Development Facilitation Team (DFT) – Review Comments

DRB Project No: PR-2020-003485 Date: 04/26/2023 Agenda Item: #7 Zone Atlas Page: J-14

Location: 401 LOMAS BLVD NW between 4th ST and 5th ST

Application For: SD-2023-00066-VACATION OF RIGHT-OF-WAY (DHO)

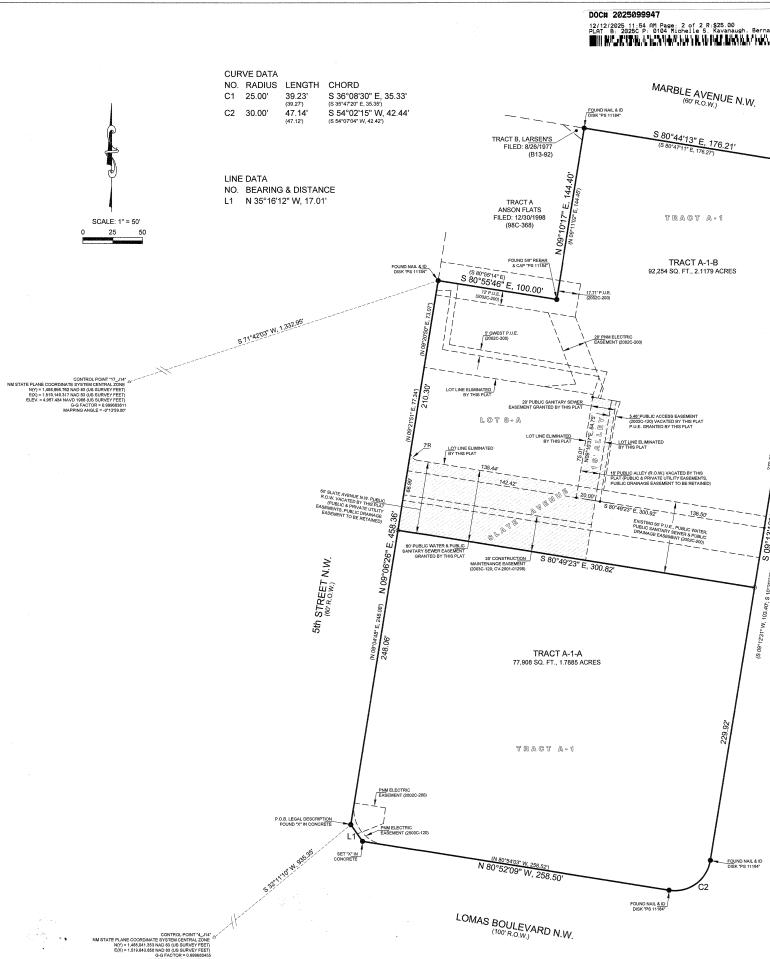
1. Coordinate with 811 and provide an exhibit showing the public water and sanitary sewer infrastructure that is within the corridor proposed to be vacated.
2. There is an existing water and an existing sanitary sewer within the public right-of-way that will require proper access to operate and maintain.
3. Provide the plat or proposed lot consolidation to demonstrate the final layout. The infrastructure on-site will require proper easement and surface access.
 - a. A 25' min easement is required for two public lines.
 - b. The easement corridor must be accessible for operation and maintenance.

1. This corridor has an existing public sanitary sewer line that must have a public easement
2. A minimum 20' easement must be in place for the existing line.

- Hydrology has no objection to the Vacation of the Public Right of Way (16' Alley and 60' R.O.W. of Slate Road).
- Prior to platting, **Hydrology will need some sort of drainage exhibit with the current drainage patterns. Public Drainage Easements over the vacated 16' Alley and 60' R.O.W. of Slate Road may be needed.**
